Planning and Development Acts 2000 to 2021

Planning Authority: Dún Laoghaire-Rathdown County Council

Planning Register Reference Number: Ref11021

WHEREAS a question has arisen as to whether the following works at Apartment Q, Coliemore Apartments, Dalkey, County Dublin, constitutes development and if so whether that development can be considered exempt development:

WORKS ITEM 8

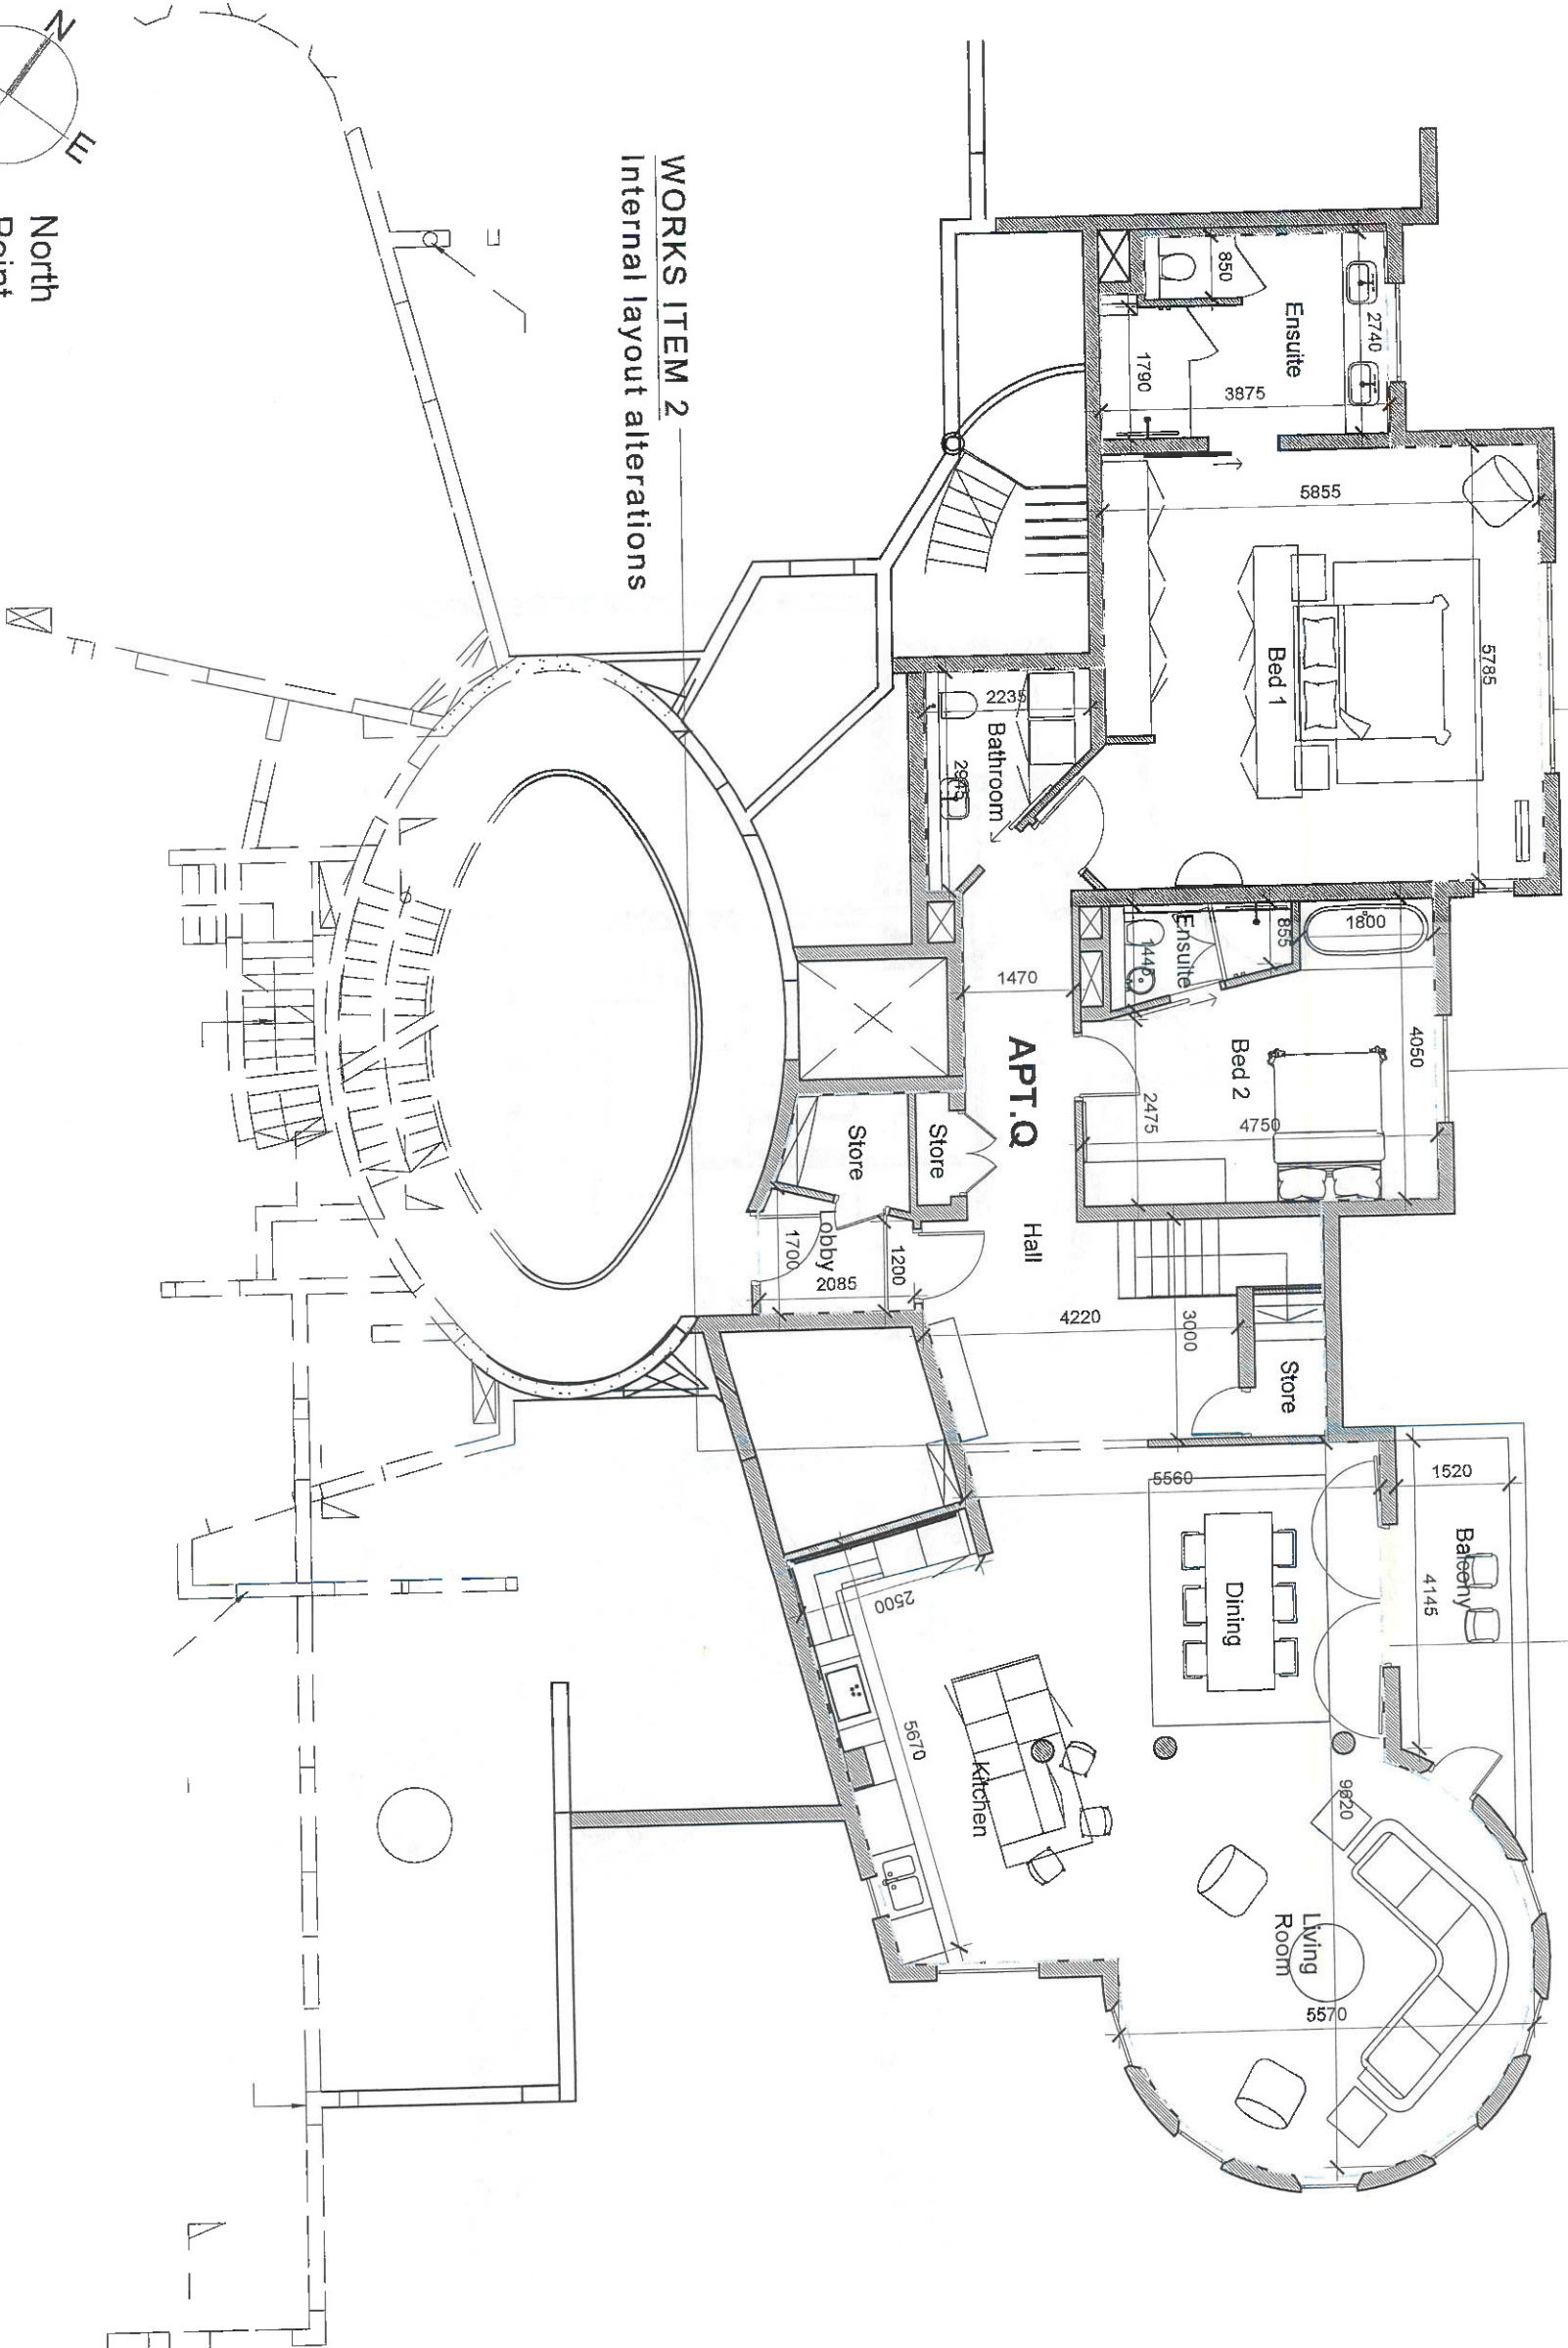
7. Changing of window on north-east elevation at second floor to double doors to access existing rear facing roof terrace.
8. Changing of fenestration division of four number windows on north-east elevation at second floor:

AND WHEREAS An Bord Pleanála has concluded that Works Items numbers 1 to 8 are works involving the improvement or alteration of the structure which would affect only the interior of the structure, or which do not materially affect the external appearance of the structure so as to render the appearance inconsistent with the character of the structure or of neighbouring structures:

NOW THEREFORE An Bord Pleanála, in exercise of the powers conferred on it by section 5 (3) (a) of the 2000 Act, hereby decides that at Apartment Q, Coliemore Apartments, Dalkey, County Dublin, the works outlined above in item numbers 1 to 8 are development and are exempted development.

Proposed Side Elevation A
 1.100

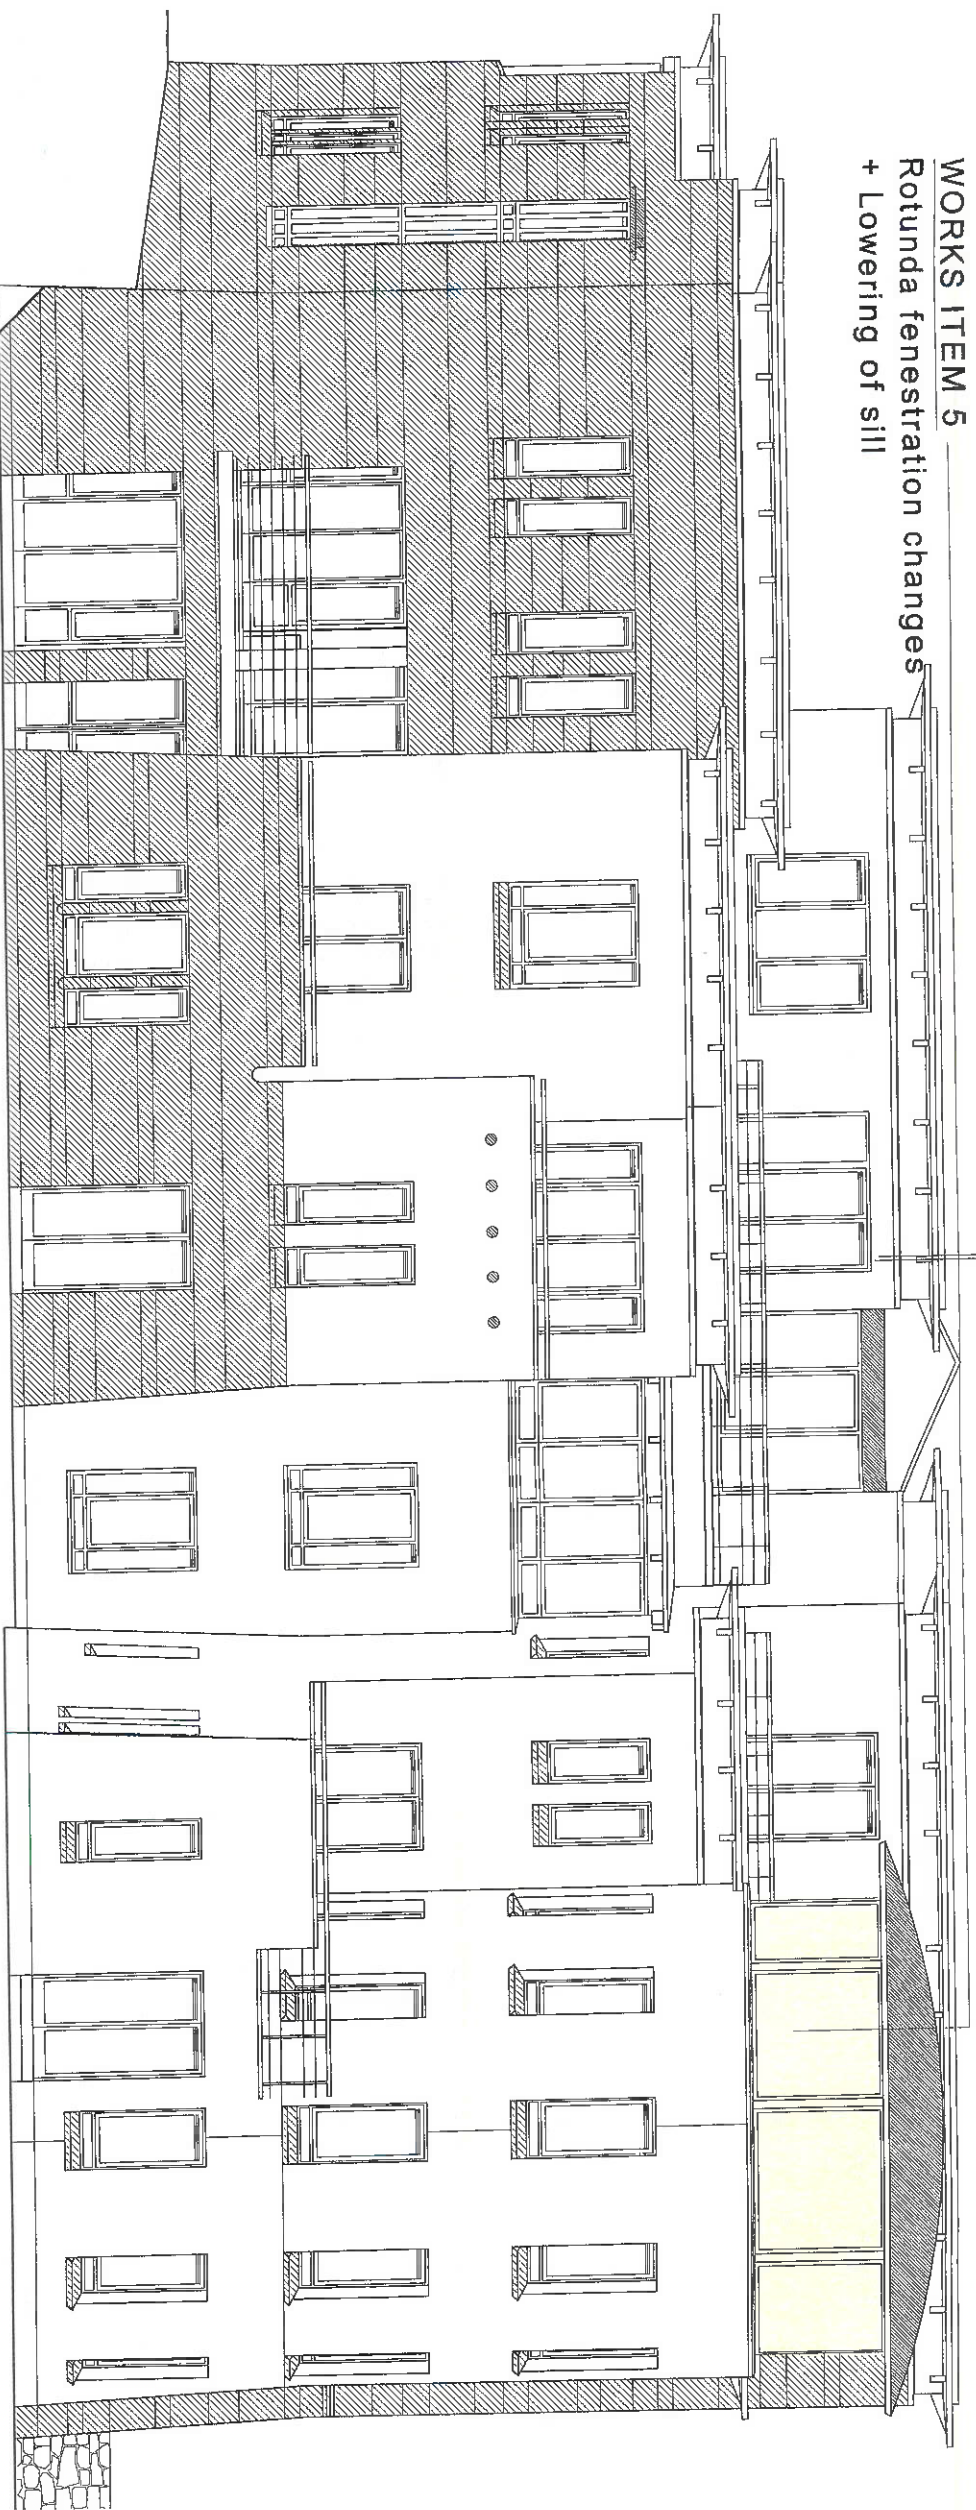
5. Rotunda fenestration changes and lowering of sill - A combination of item numbers 3 and 4 above to consist of lowering of rotunda sill and changing seven number groups of three number windows to seven number curved fixed windows.

WORKS ITEM 6

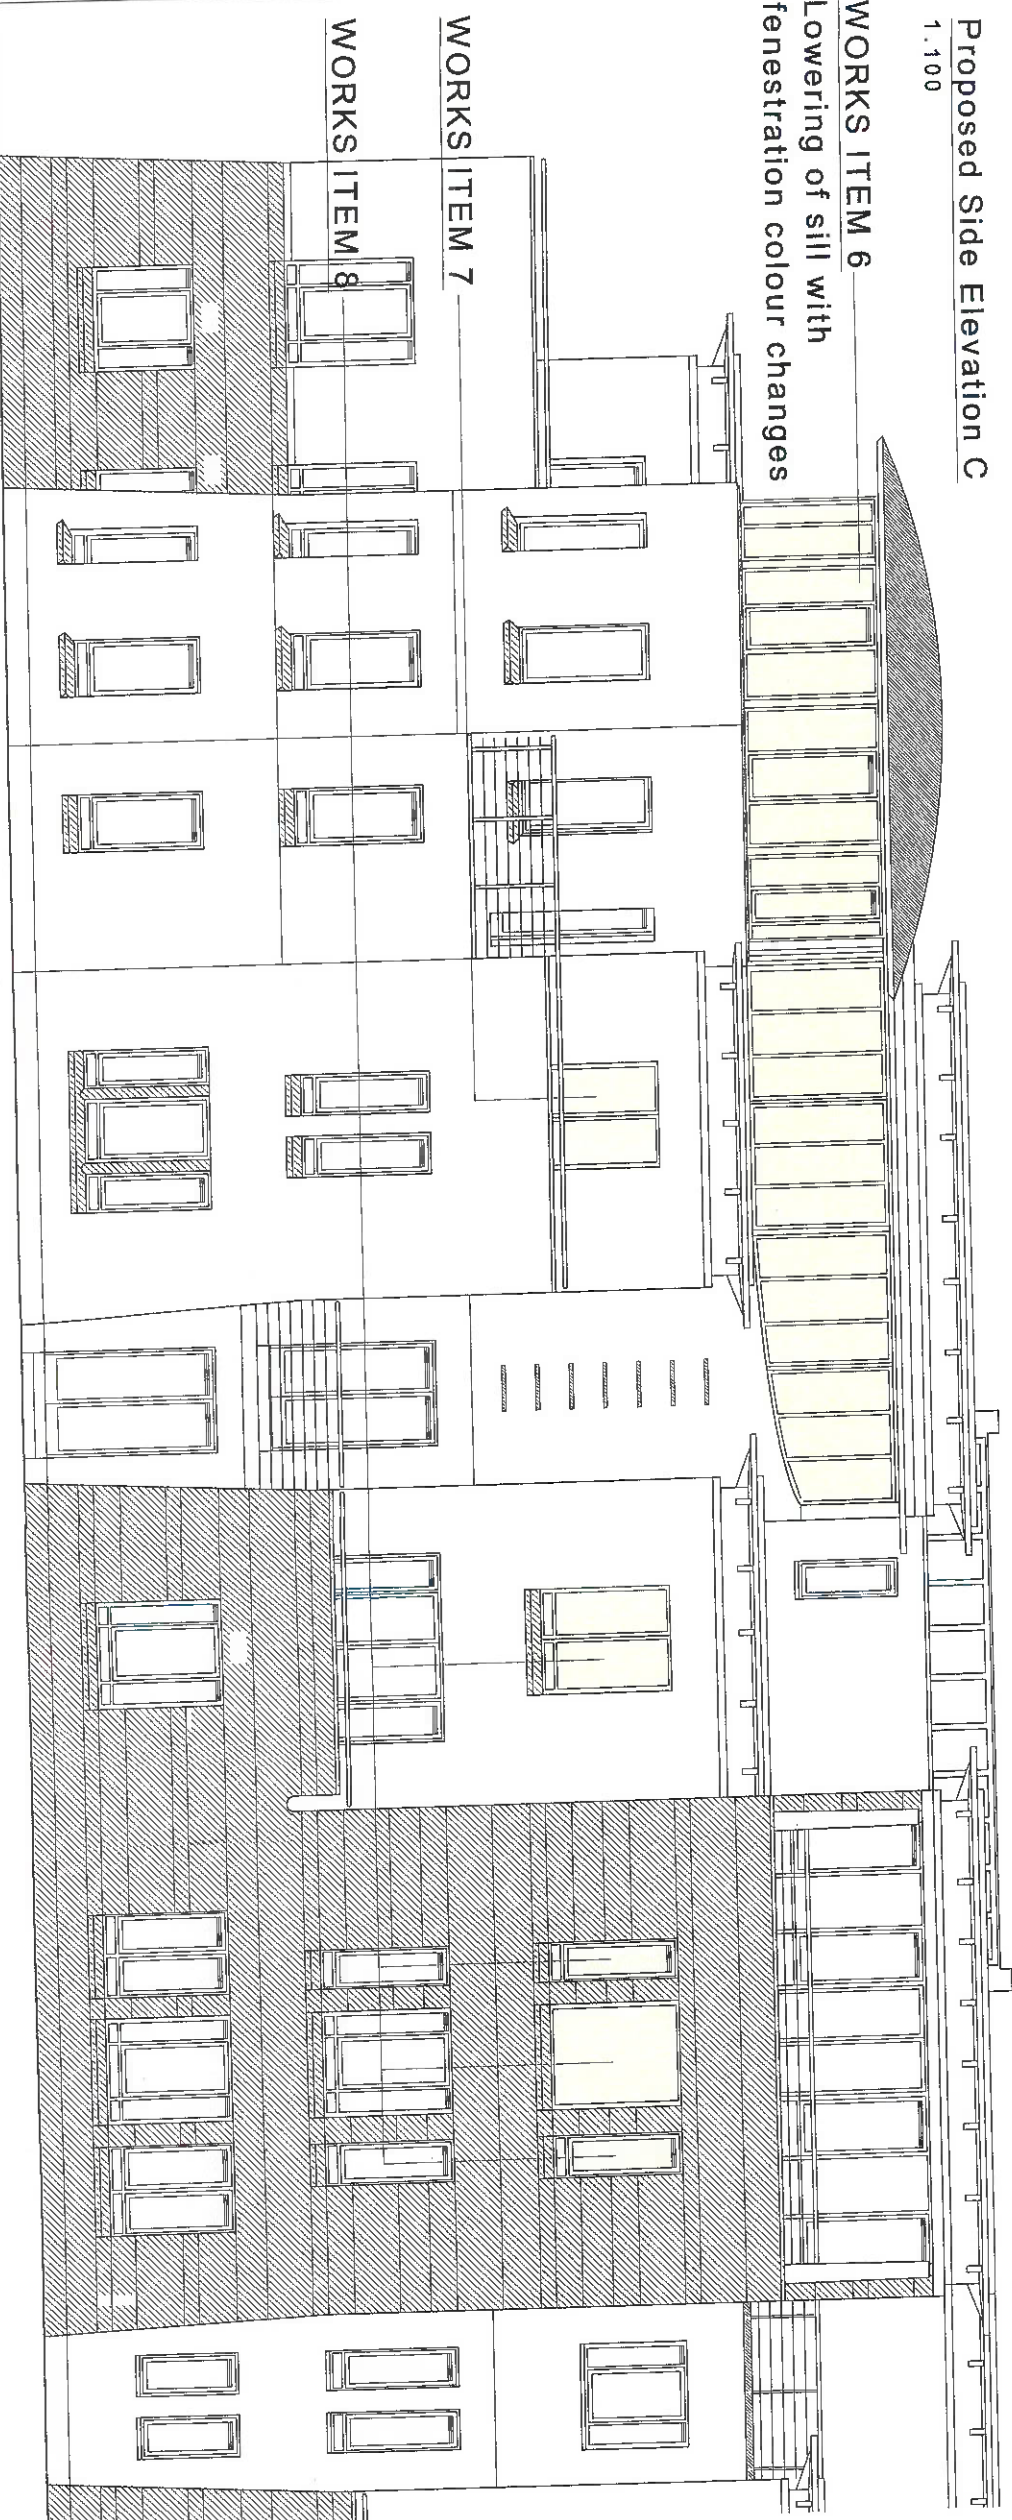
6. Lowering of sill with fenestration colour change -Lowering of rotunda sill as per item number 3 but retaining the same fenestration division with replacement of third floor aluclad windows to rotunda/north-east (rear) elevation to aluminium windows with a dark grey powder coated finish (RAL 7043/Traffic Grey).
